The Drovers Solar Farm

Applicant's Response to Written Representations and other Deadline 2 Submissions

PINS reference: EN0110013

Document reference: APP/8.16 (Original)

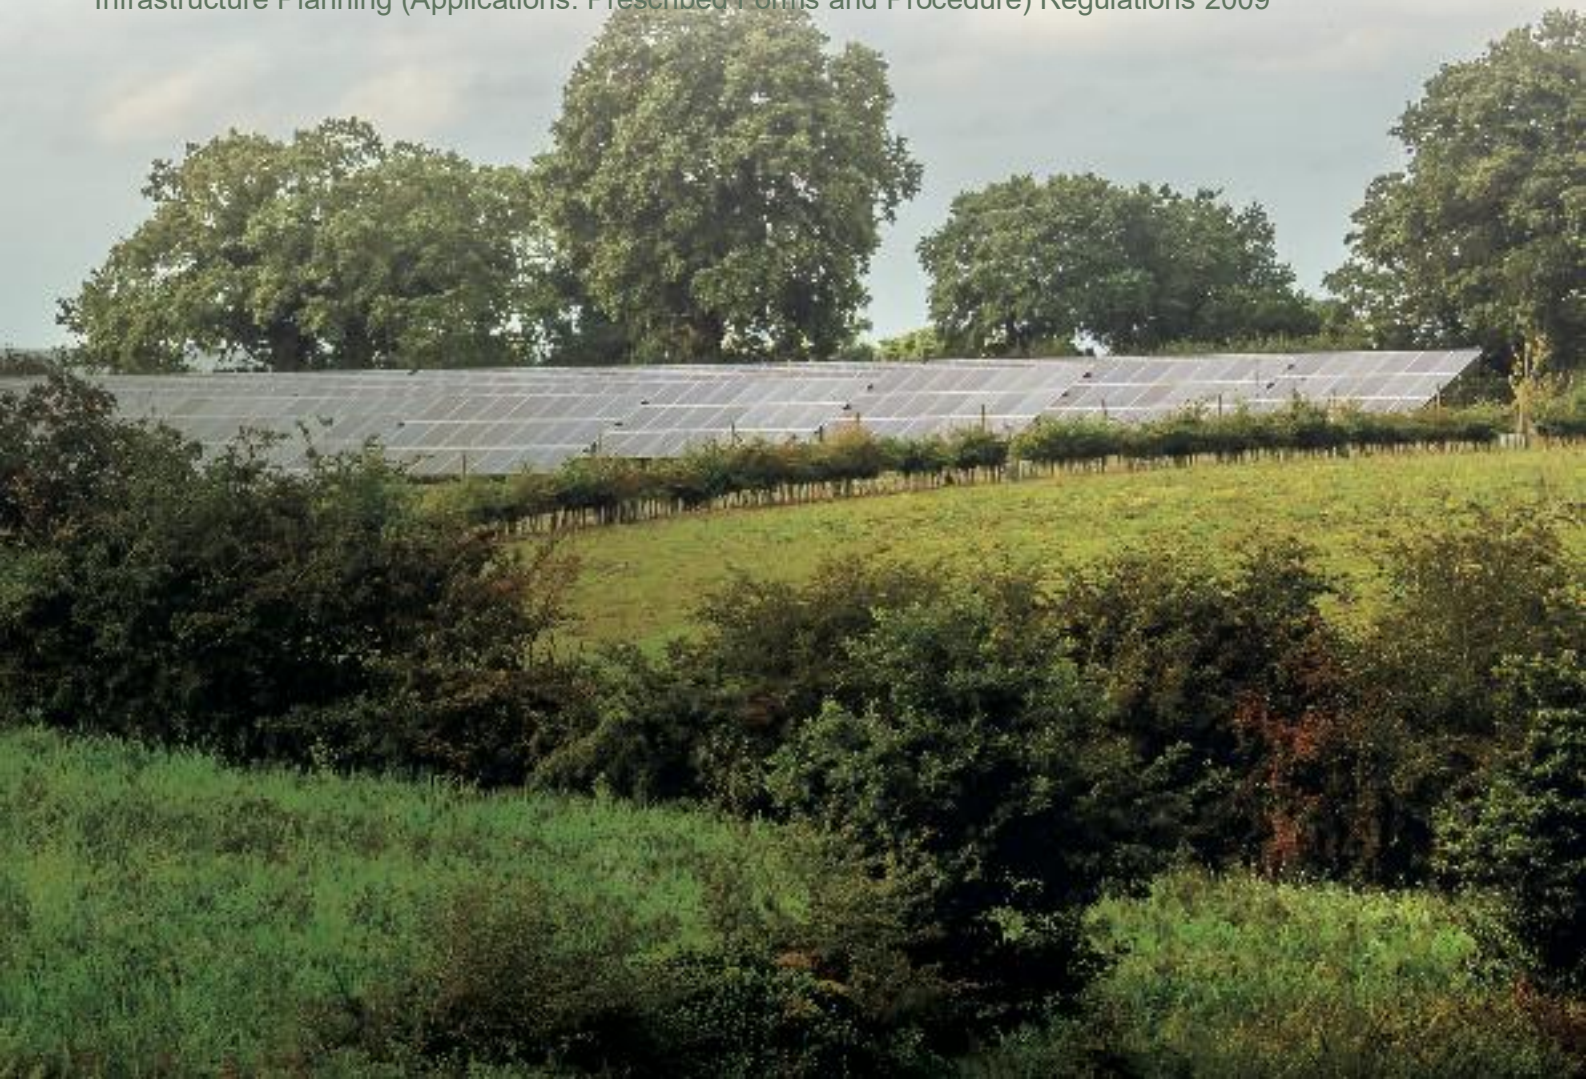
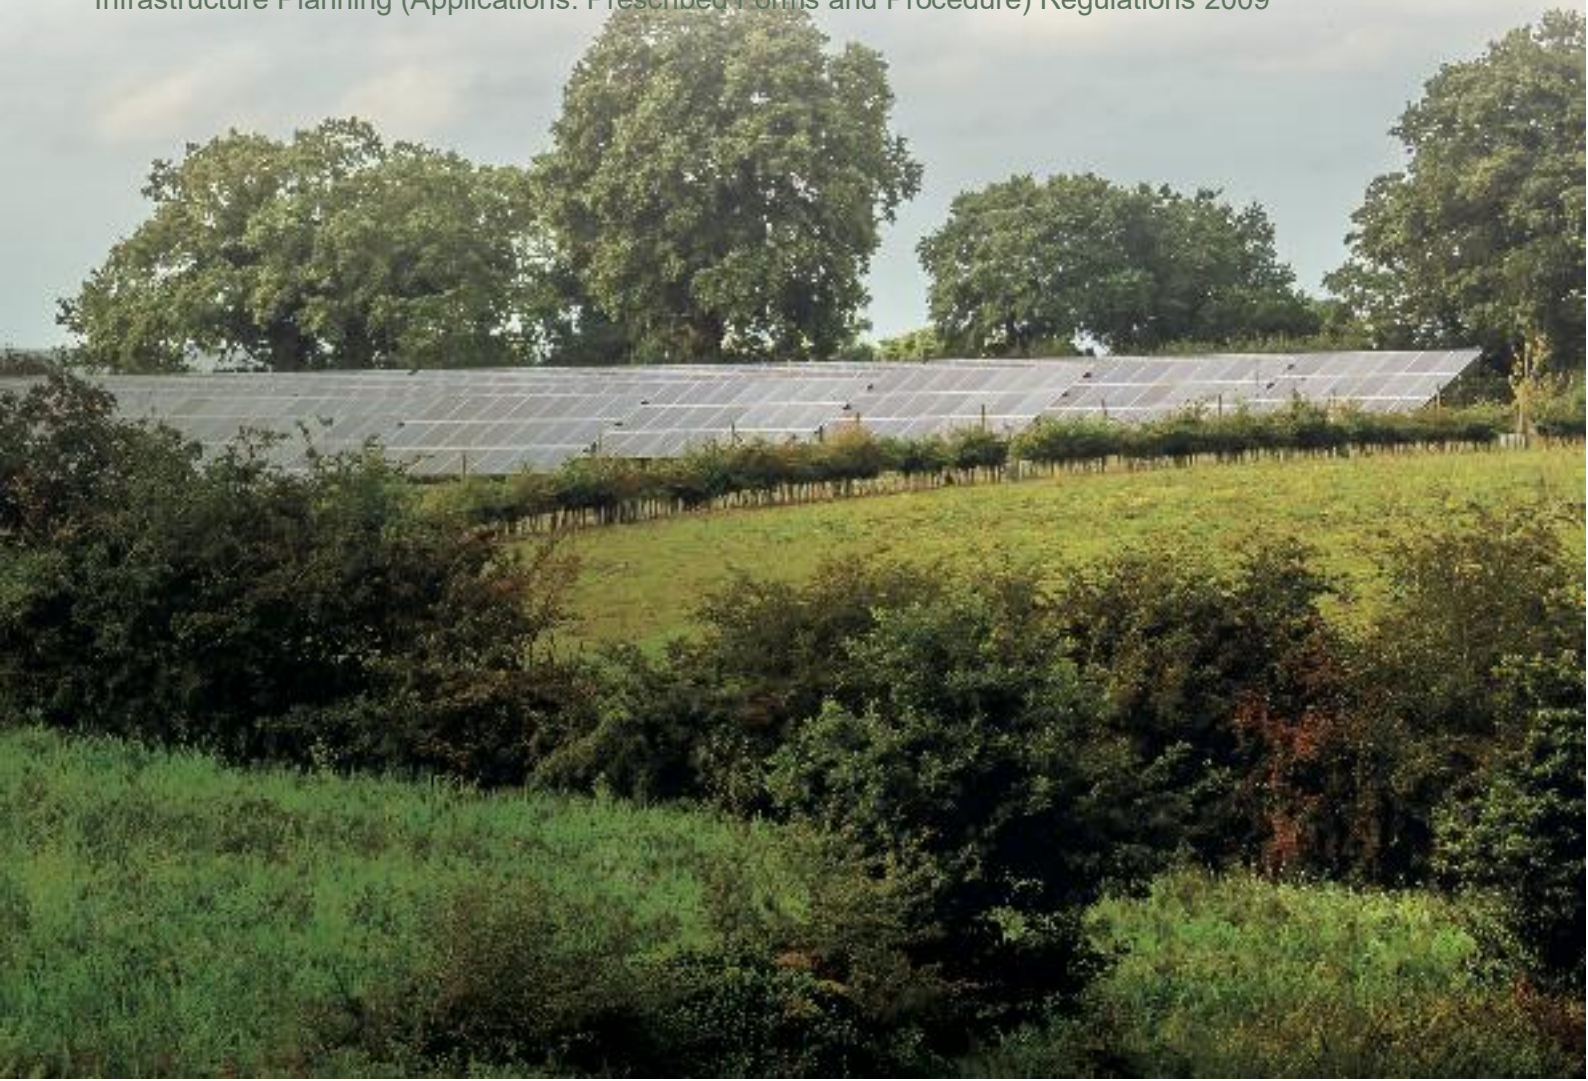
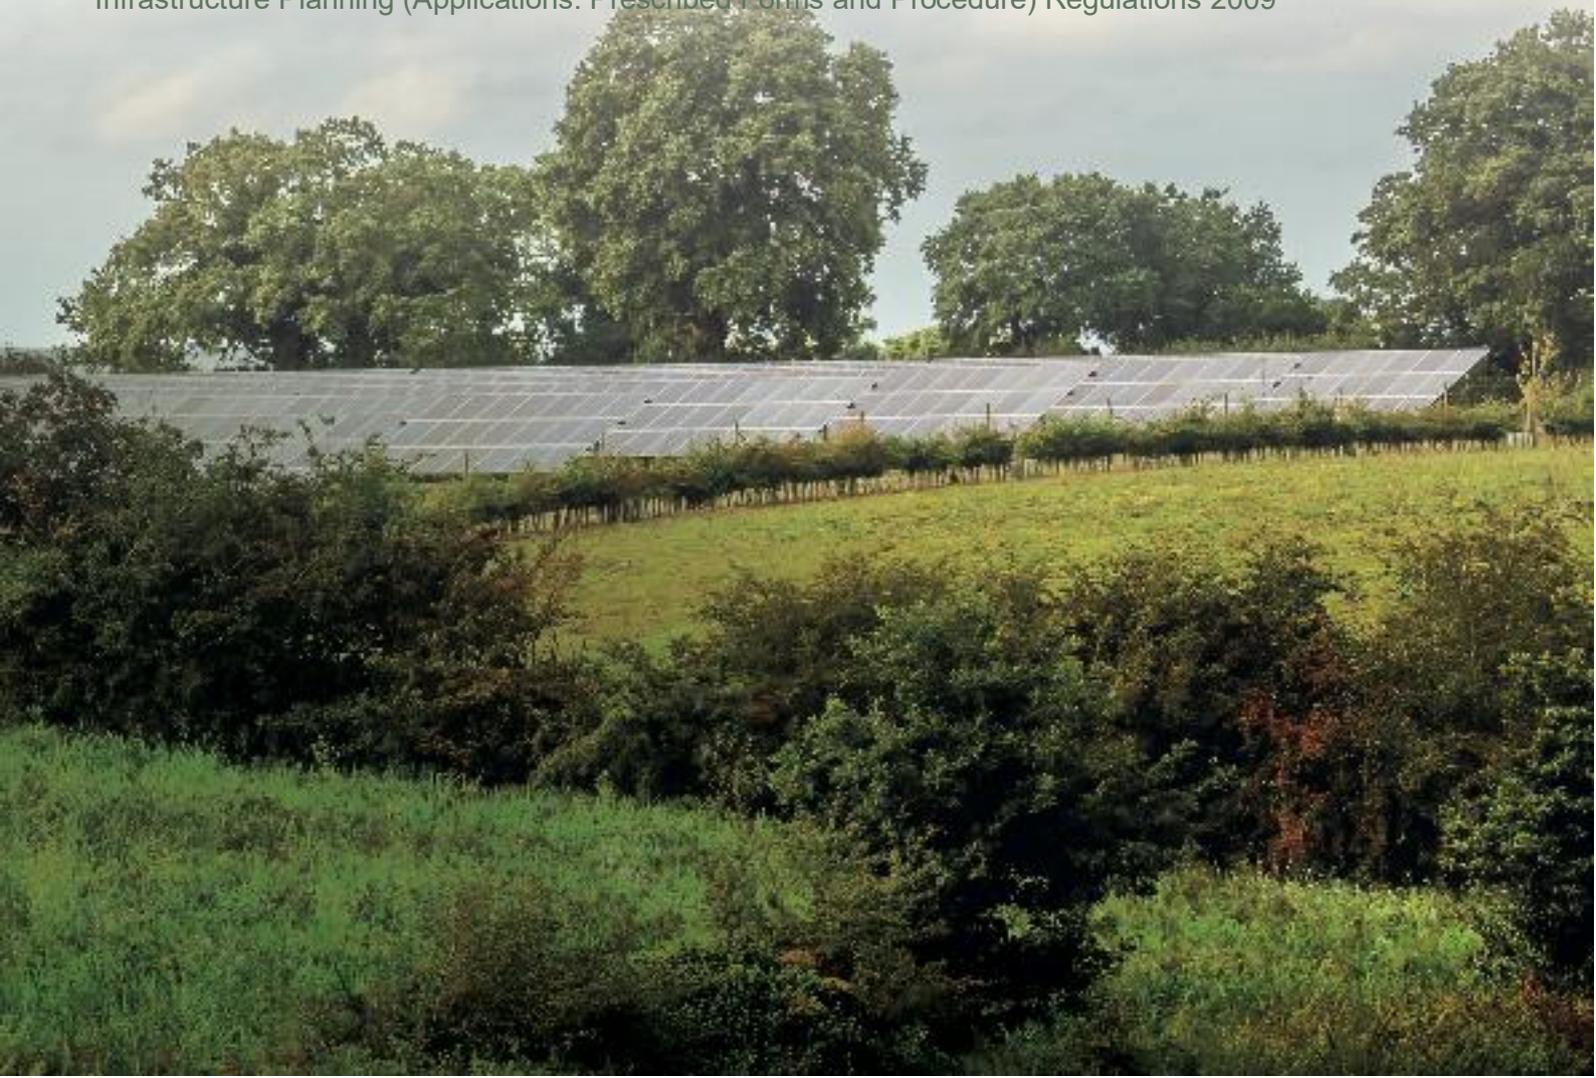
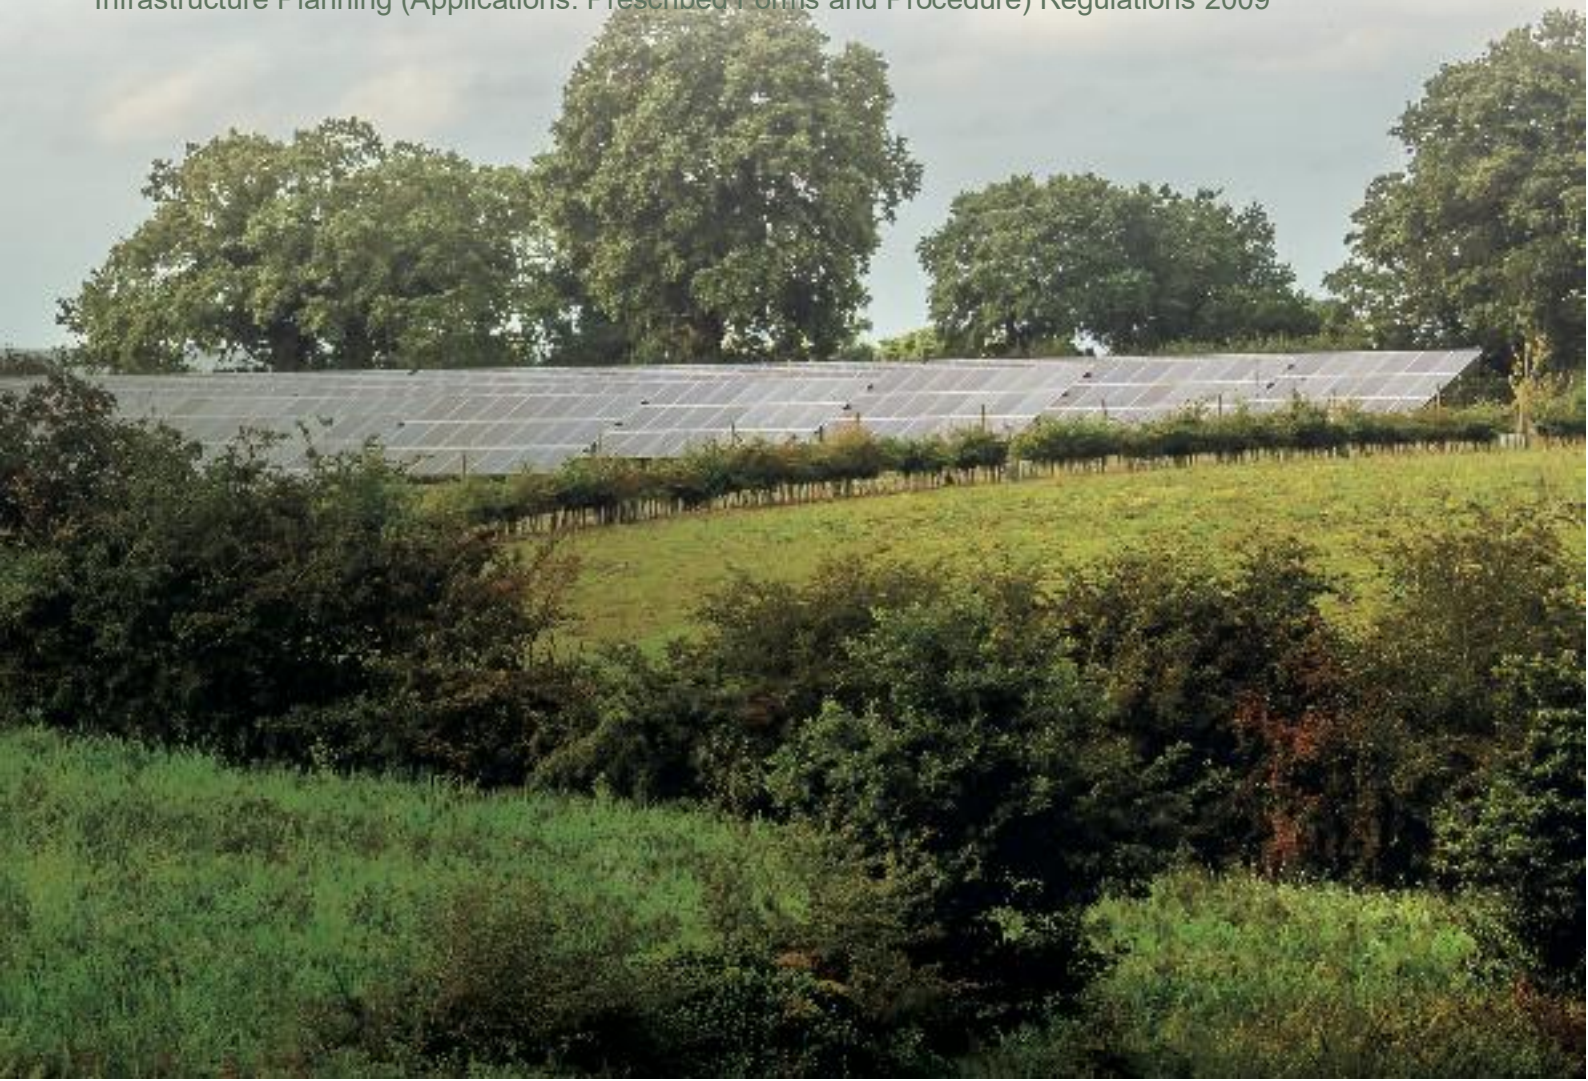
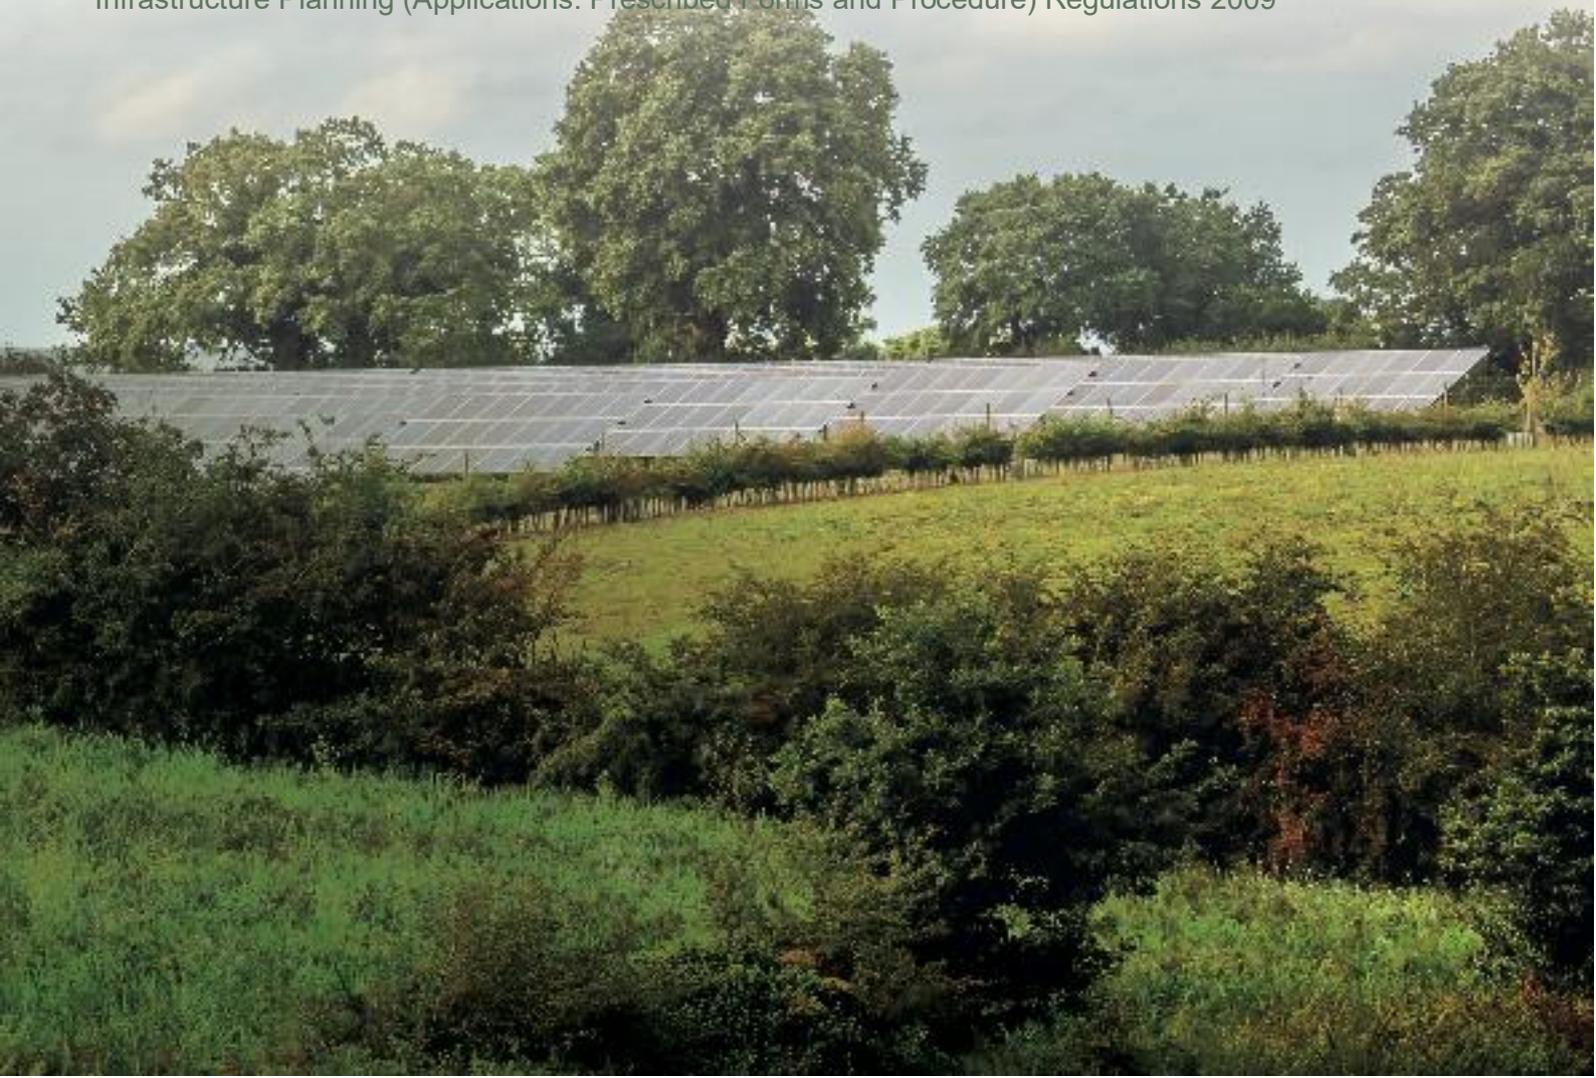
Reference	Comments	Applicant's Response
NCC3	Pages 5 and 6, Para. 5.2 <i>Landscape and Visual</i> It remains concerned that it will not be possible to mitigate much of the landscape impact and it agrees comments received about the visualisations, that providing dotted lines on a photograph does not adequately represent the impact.	Whilst it is not possible to entirely remove the impacts on landscape character through visibility or the appearance of the proposed Solar PV arrays, the effects can be reduced over time through the embedded mitigation measures. The majority of solar developments will result in some residual landscape and visual effects once the embedded mitigation measures have established and this is to be expected for virtually any greenfield ground mounted solar PV development. The embedded mitigation measures are outlined in paragraph 6.7.22 of ES Chapter 6: Landscape and Visual [AS-016]. Whilst there would be a change in the character and appearance of the Site itself, the majority of the physical landscape features would be retained and enhanced through the implementation of the outline Landscape and Ecological Management Plan (oLEMP) [APP/7.11.2]. Photowire visualisations have been provided based upon the Scheme parameters in both the winter and summer months to inform the findings of ES Chapter 6: Landscape and Visual [AS-016]. These include: • ES Figure 6.12: PM6, PM8, PM12 and PM14 Parameter Based Winter Photowires [AS-023] [AS-025] [AS-027] [AS-029]; and • ES Figure 6.13: PM6, PM8, PM12 and PM14 Parameter Based Summer Photowires [AS-031] [AS-033] [AS-035] [AS-037]. These photowire visualisations show the Scheme parameters as an overall massing model to indicate the 'worst case scenario' in accordance with the adopted (and standard practice) Rochdale envelope principles. In addition, illustrative photomontages have been provided to show the design principles and initial design concepts as photorealistic montages. These include: • ES Figure 6.14: PM8, PM12 and PM14 Winter Photomontages - Illustrative Scheme [APP/6.3.2]; and • ES Figure 6.15: PM8, PM12 and PM14 Summer Photomontages - Illustrative Scheme [AS-045] [AS-047] [AS-049]. Furthermore, additional illustrative photomontages have been provided within Appendix 4 of the Technical Information Note – Landscape and Visual [APP/8.18] at Deadline 3, as requested by Breckland Council and include ES Figure 6.17: Additional Summer Photomontages: Illustrative Scheme which is contained within Technical Information Note – Landscape and Visual [APP/8.18]. The photowire visualisations showing the Scheme parameters are considered to adequately represent the 'worst case scenario' in terms of the maximum visual impacts to inform the findings of ES Chapter 6: Landscape and Visual [AS-016].
